Our Ref: FG/135/19/PL
Your Ref:

Town & Country Planning Act 1990 (as amended)
Town and Country Planning (Development Management Procedure) (England) Order 2015
Application for Planning Permission

Development Demolition of a Silo & erection of an office building (B1(a) Business), 6 No. parking spaces for office workers & erection of boundary fencing.
Location Silo at Former McIntyre Nursery Littlehampton Road Ferring

1 Ground Level
1 : 50

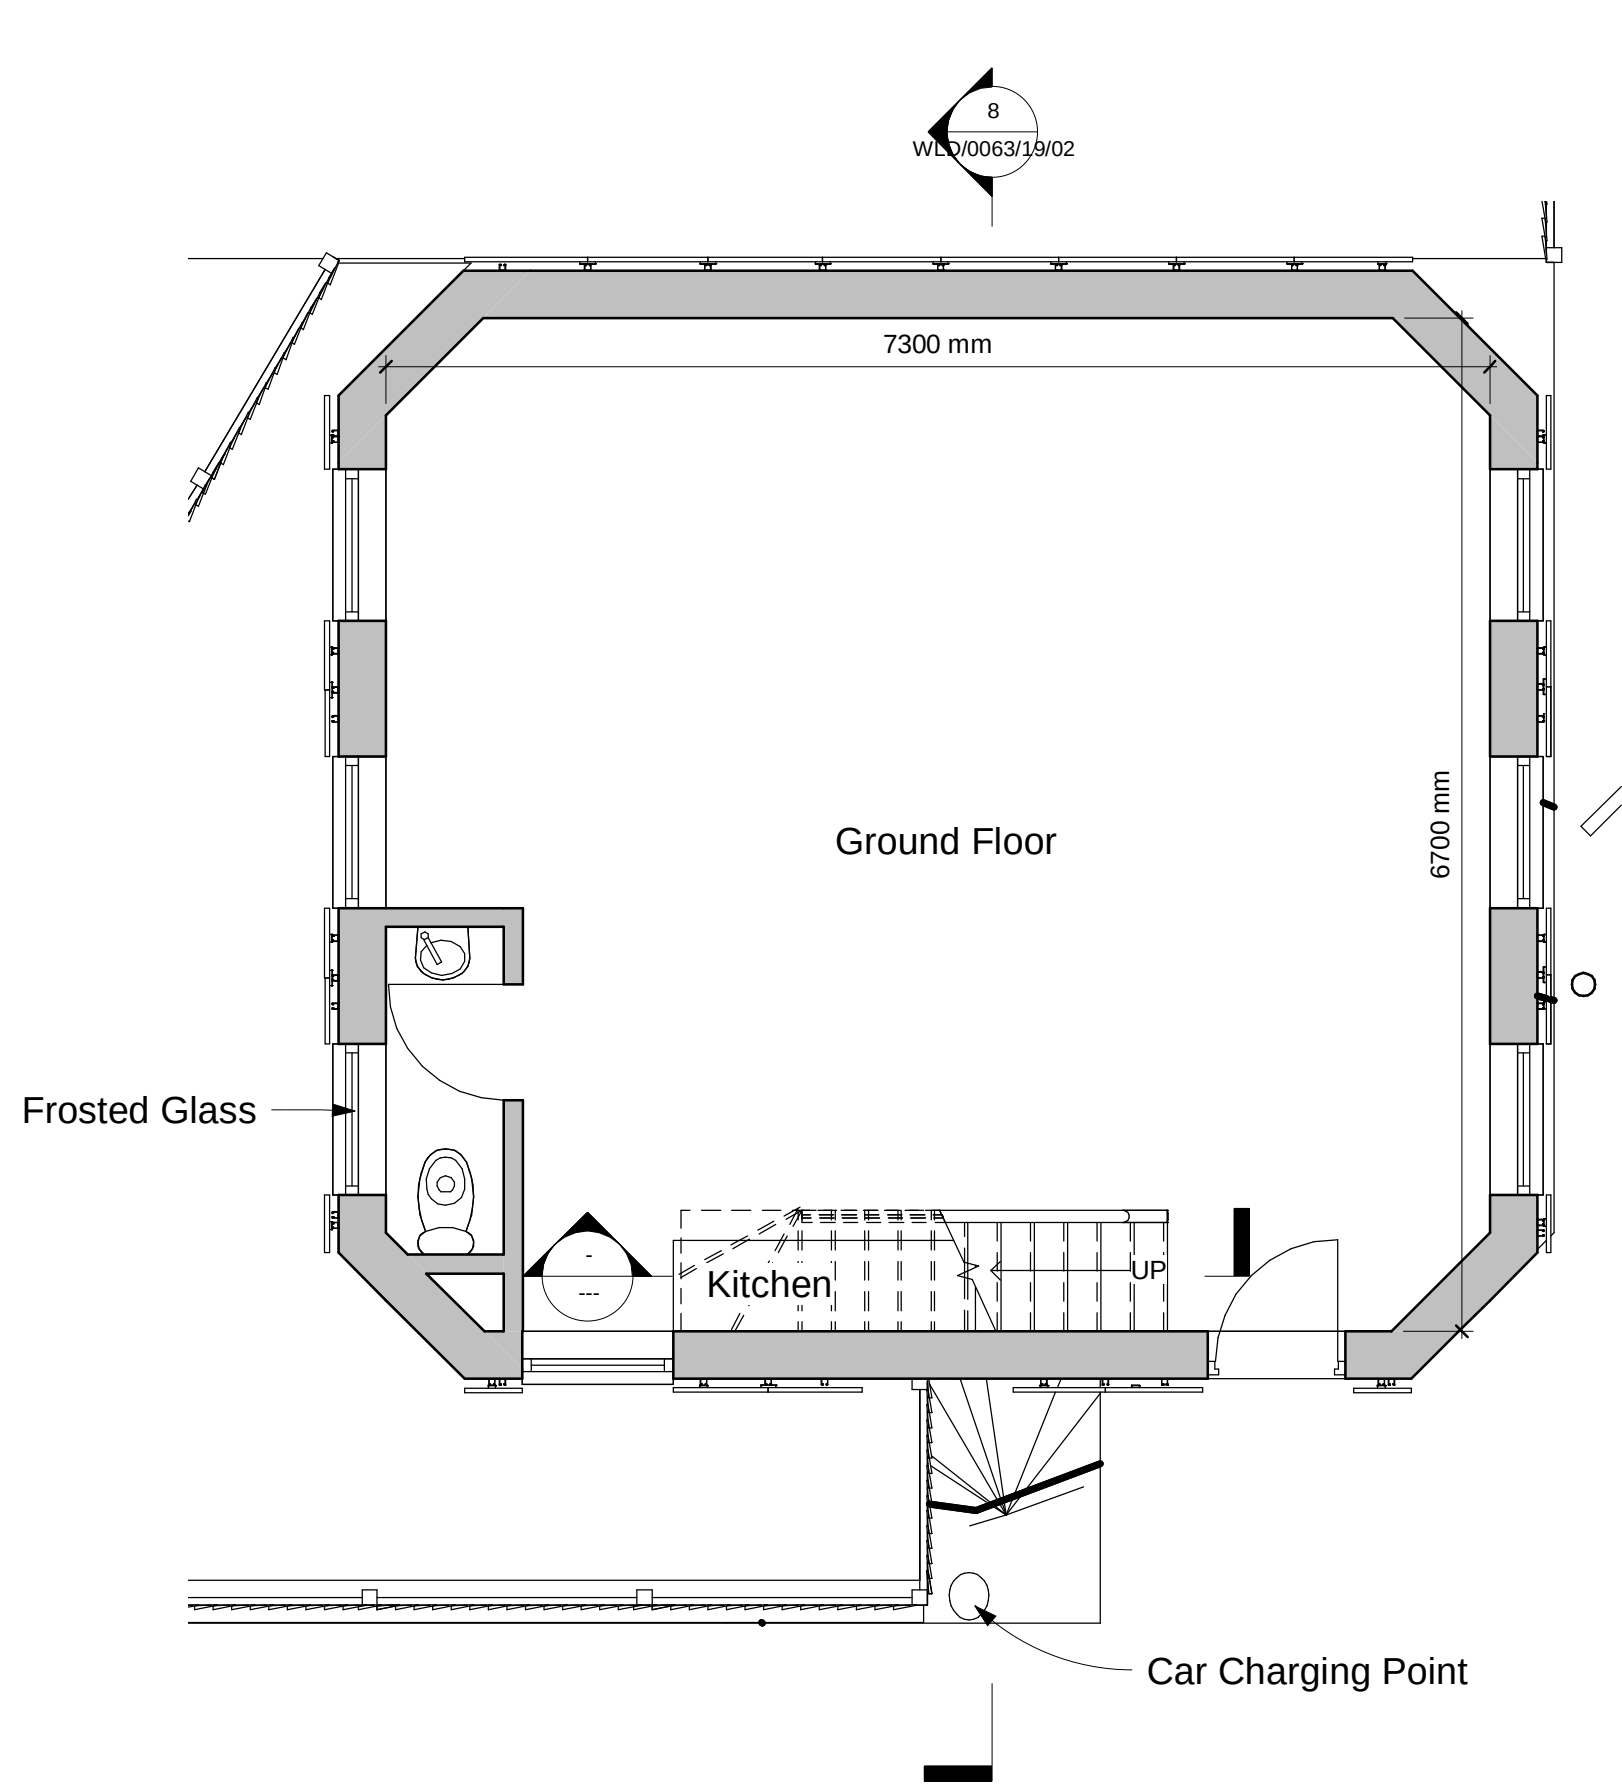
Please show the position of the bins on the proposed ground floor plan.
